**PR-2023-008674**  
**SD-2024-00163 – FINAL PLAT**

**TIERRA WEST, LLC agent for BUTTERFLY HOLDINGS LLC requests the aforementioned action(s) for all or a portion of: NE Corner Tr 310; The N'ly Ports of TS 308, 309 & 310; Tr Comprising Por TR 310, UNIT 8 ATRISCO GRANT zoned MX-T, located at 5720 MIAMI RD NW containing approximately 5.4683 acre(s). (H-11)**

**REQUEST:** Final Plat for Playa Del Sur

**Project Name:** Playa del Sur Subdivision

**Plat for
Playa Del Sur
Being Comprised of
Portions of Tracts 308, 309 and
310, Unit 8, Town of Atrisco Grant
City of Albuquerque
Bernalillo County, New Mexico
January 2024**

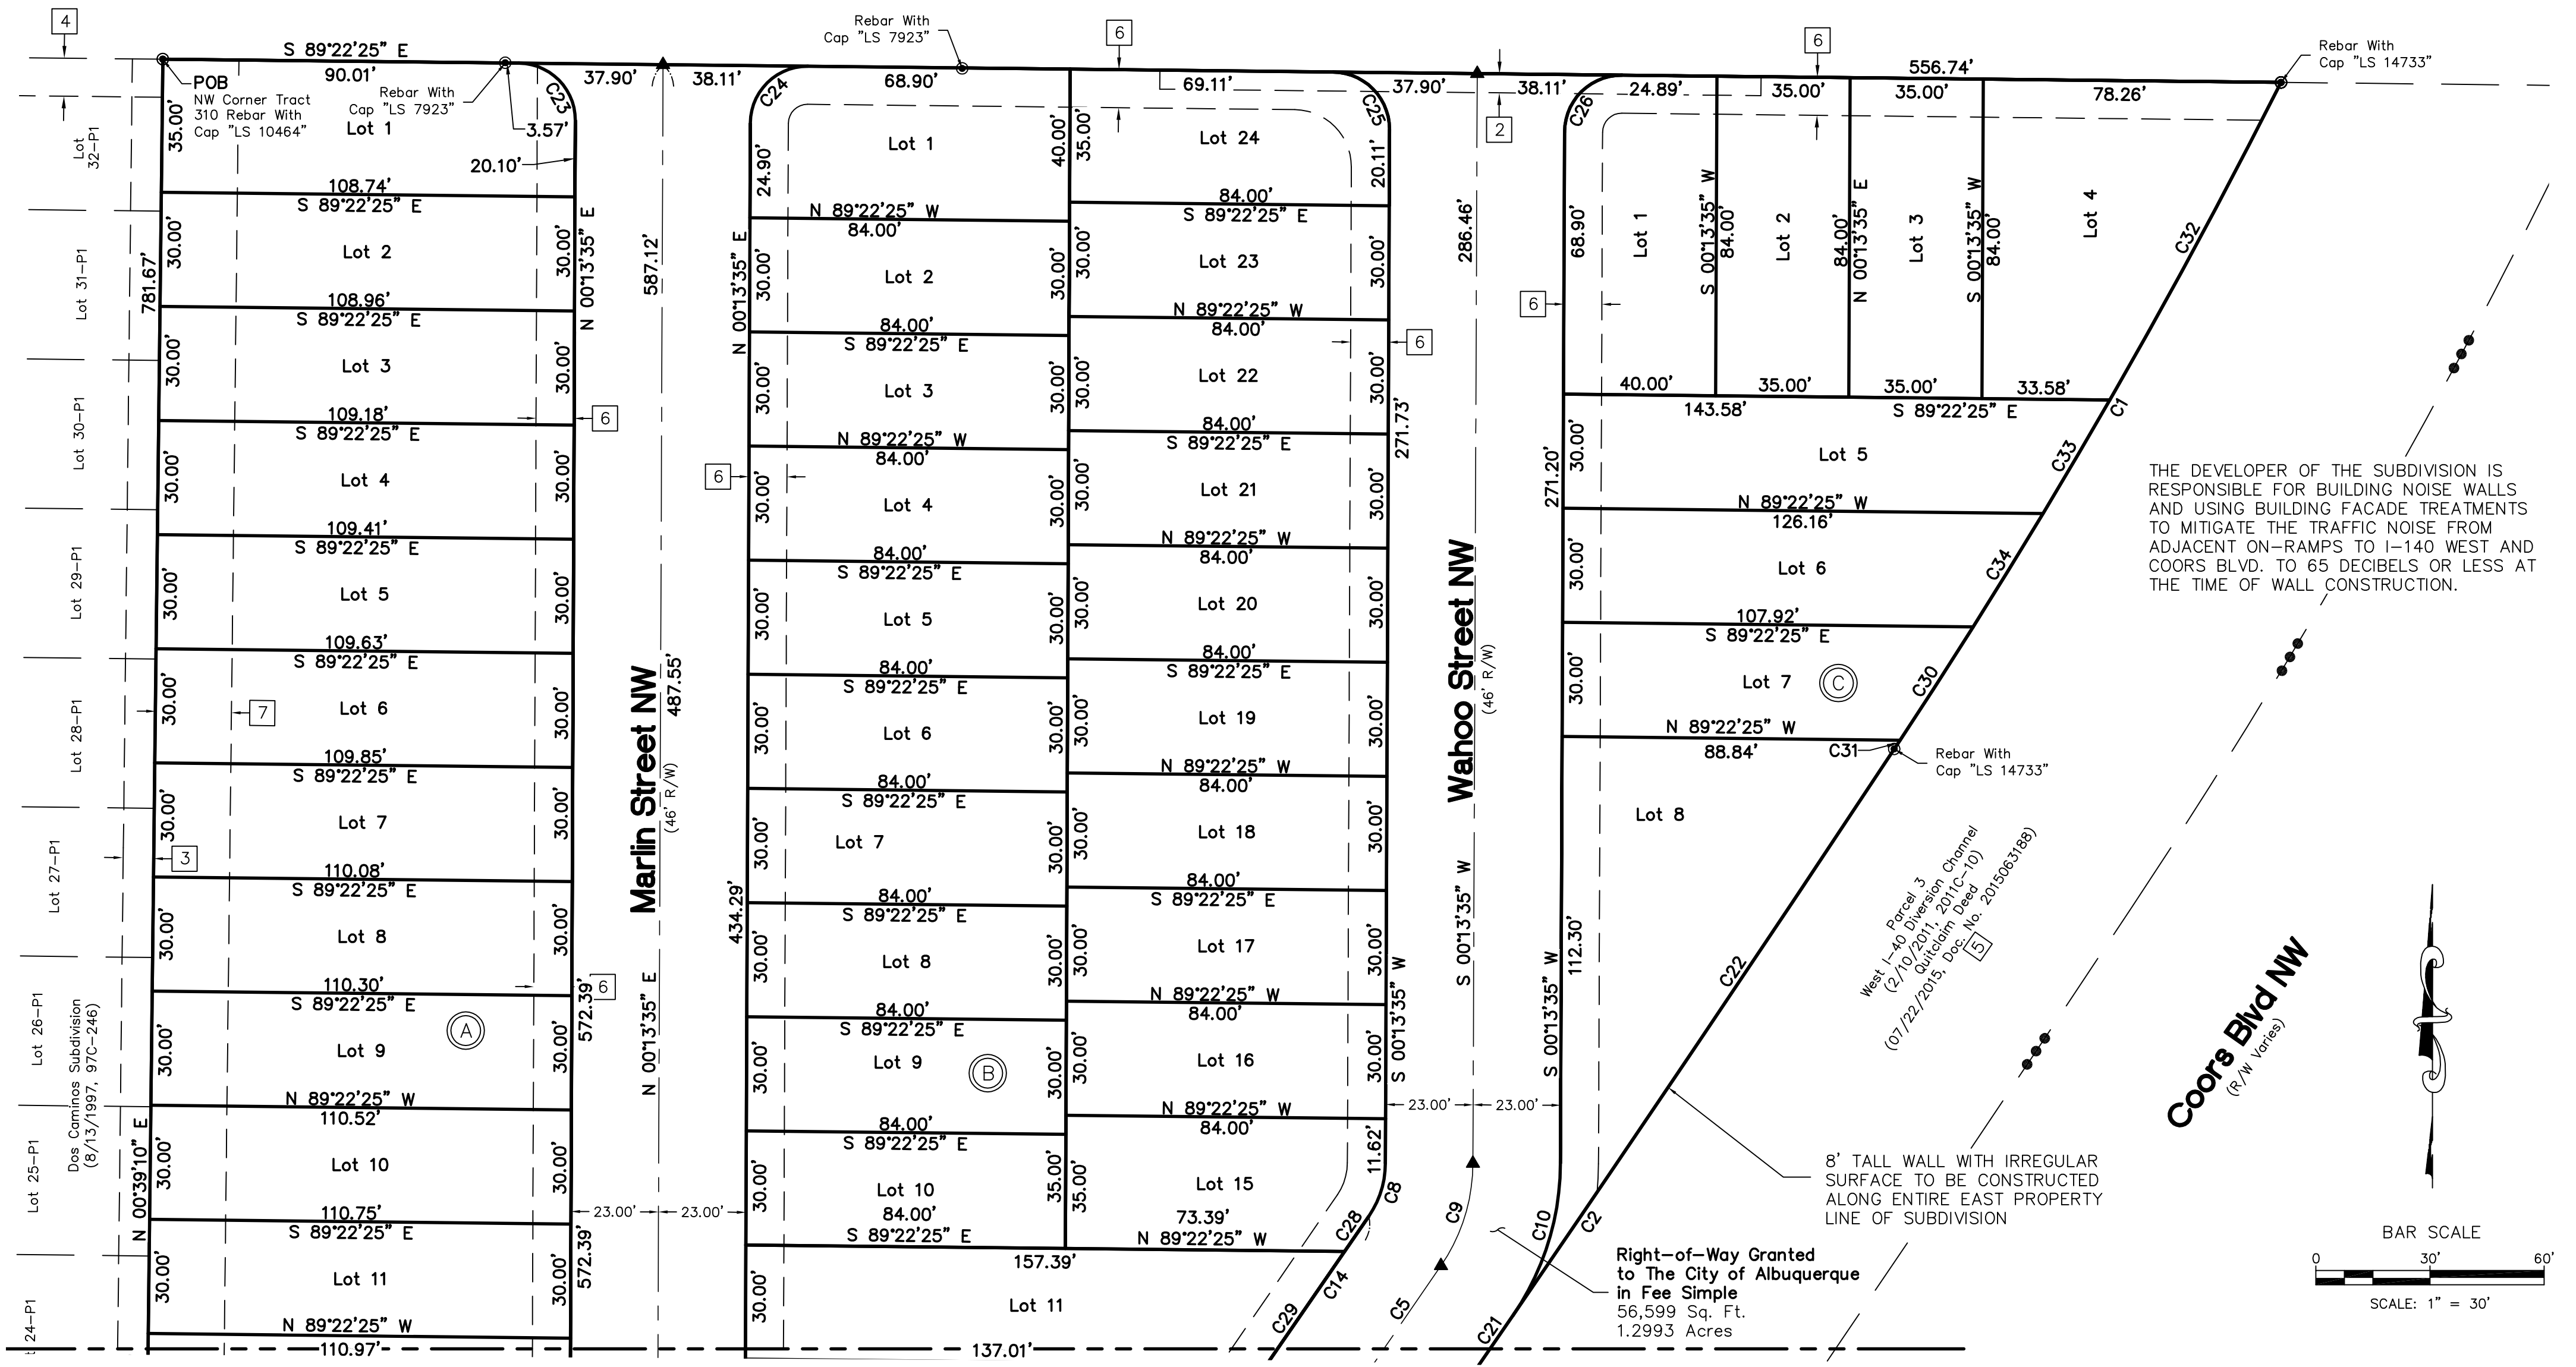
This condition is partially met with a label for this wall on Sheet 3. Please modify to the exact language above which includes 6 inches wide and the wrap around the corner with Lot 4 on Miami Road for a distance of 35-50 feet, stepping down as it approaches the front façade. This note must be added to Sheet 4 as well.
